WEST SUSSEX COUNTY COUNCIL CONSULTATION

TO:	Arun District Council FAO: Richard Castro-Parker
FROM:	WSCC - Highways Authority
DATE:	28 August 2019
LOCATION:	Land adjacent to 3 Wicks Farm Cottages, Ford Lane, Ford, BN18 0DQ
SUBJECT:	F/18/19/PL 1 No new dwelling. This application is a Departure from the Development Plan.
DATE OF SITE VISIT:	n/a
RECOMMENDATION:	Advice
S106 CONTRIBUTION TOTAL:	n/a

Block plan 1:500

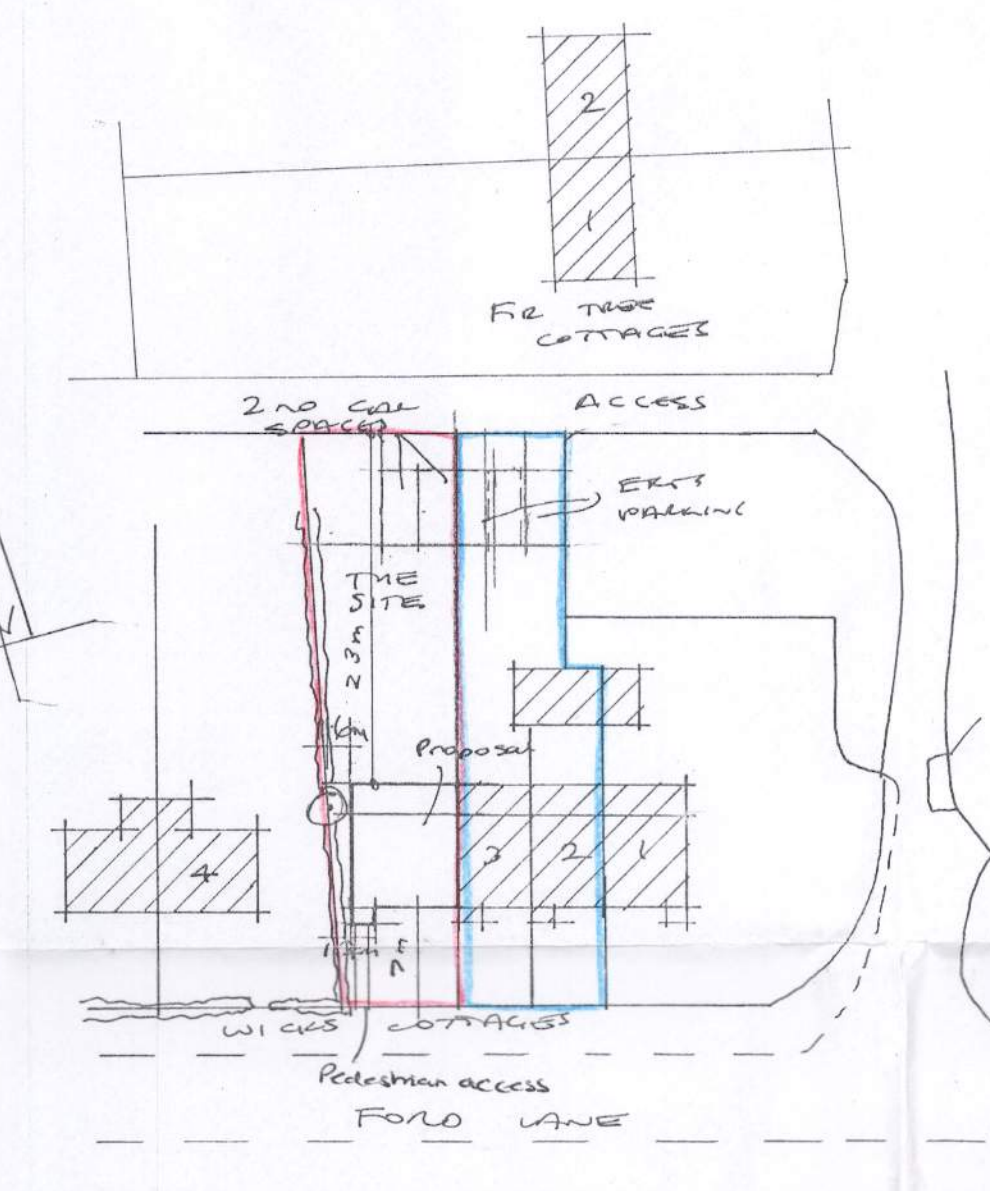
Vehicular access to the site is proposed to the rear via the existing private access track which serves the existing dwellings and agricultural use. Visibility onto Ford Lane appears sufficient to the west, but restricted to the East. However, weight is given to the fact that this is an existing access serving a number of dwellings and agricultural use. The addition of one dwelling is not anticipated to result in a material intensification of the access onto Ford Lane. Furthermore, an inspection of data supplied to WSCC by Sussex Police over a period of the past five years reveals that there have been no recorded injury accidents within the vicinity of the site. Therefore there is no evidence to suggest that the existing access is operating unsafely or that the addition of a single dwelling would exacerbate an existing safety concern.

Two car parking spaces are proposed for the dwelling. The WSCC Parking Guidance (adopted August 2019) expects that a minimum of three parking spaces would be required for a dwelling of this size and location. There appears to be sufficient space on site for this provision to be accommodated. Details of parking can be secured via condition. The proposed plans indicate that vehicles will be able to turn on site and exit onto the publicly maintained highway in a forward gear.

Car parking space (details required)

No part of the development shall be first occupied until the car parking spaces have been constructed in accordance with plans and details to be submitted to and approved in writing by the Local Planning Authority. These spaces shall thereafter be retained at all times for their designated use.
